The British Horse Society

**Holding Objection.**

**2021/92086 land at, Bradley Villa Farm, Bradley Road, Bradley, Huddersfield, HD2 2JX  
Erection of 270 residential dwellings and associated infrastructure and access**

TITLE: **PROPOSED SITE LAYOUT**

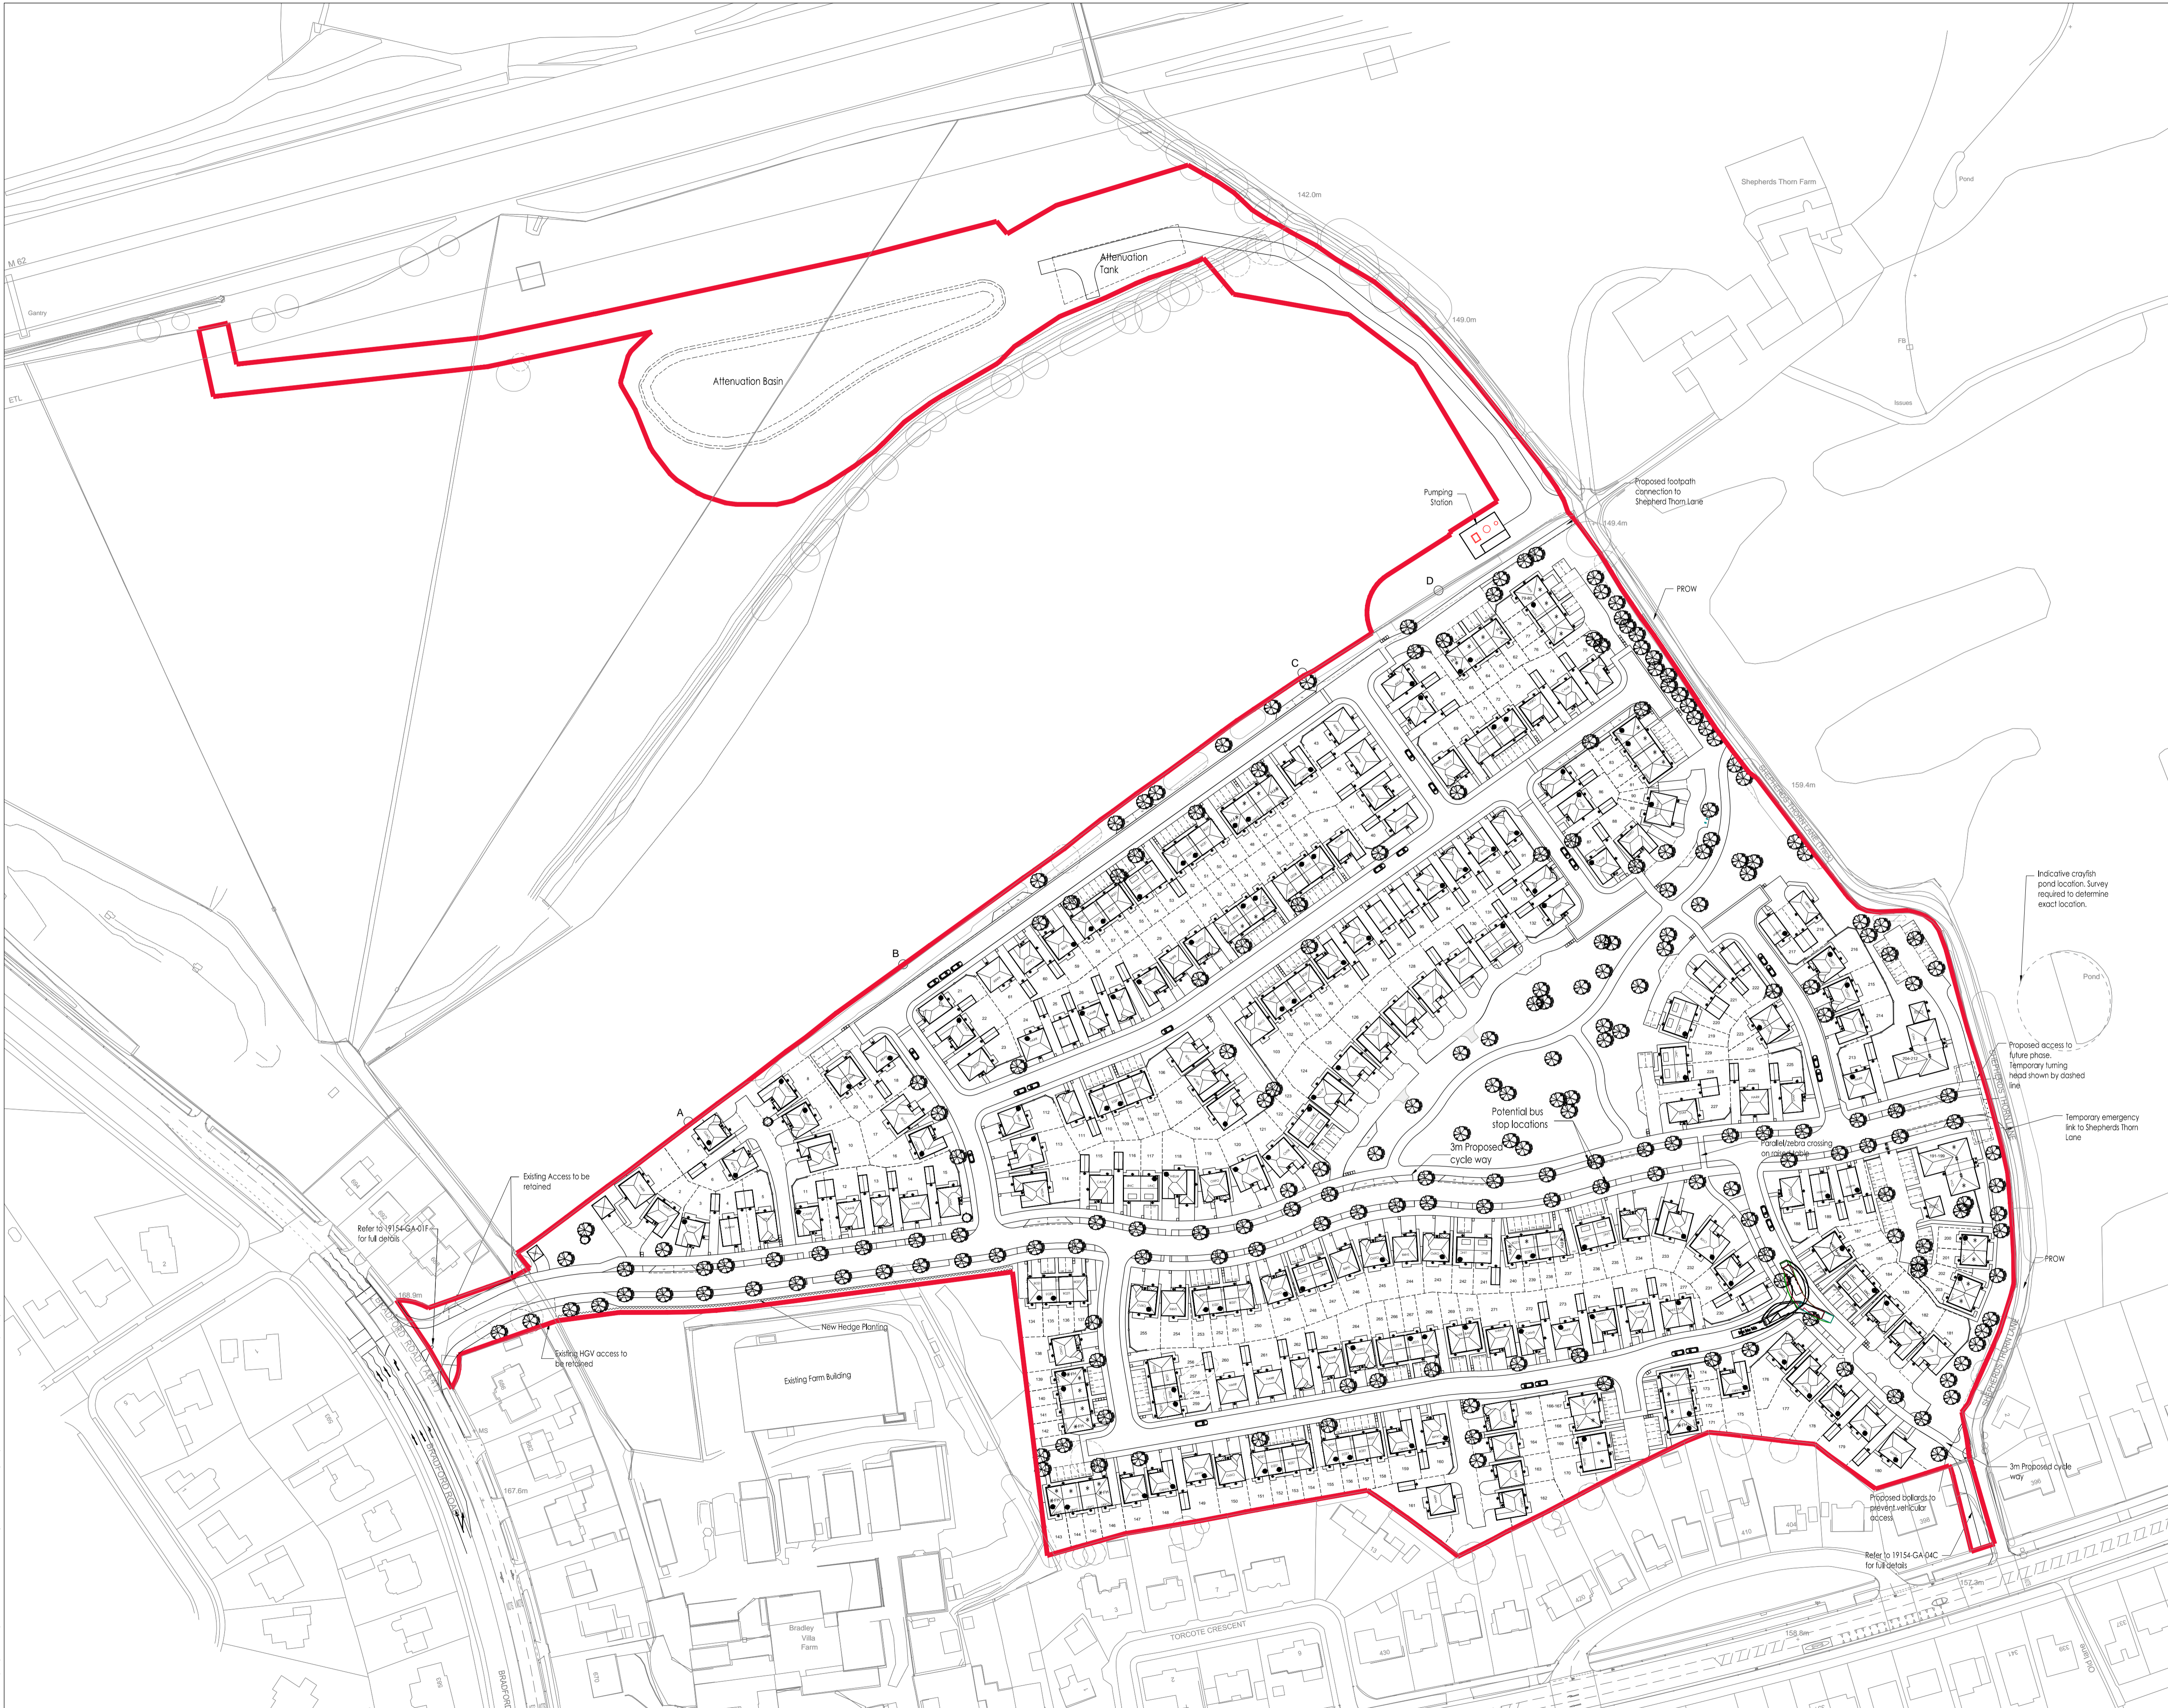
Shepherds Thorn Lane abuts the site, it remains unclear how this will be affected, we seek clarification on this point.

We would seek to have this ancient lane upgraded to a multi user bridleway, this lane is likely to receive greater use by the public as a result of this development, as such the developer should be asked to provide an improved surface of either crushed limestone or bound compacted rubber such as flexi-pave or nu-flex rubber bound compounds which are made from recycled materials being porous it is better suited to heavy rainfall in an ever-changing wetter environment due in part to global warming. We also ask that parapets be added to the bridge spanning the M62 motorway these must be 1.8 metres, this would improve the safety of the general public and in particular equestrians using this lane. We ask that the S106 contribution pays for this improvement.
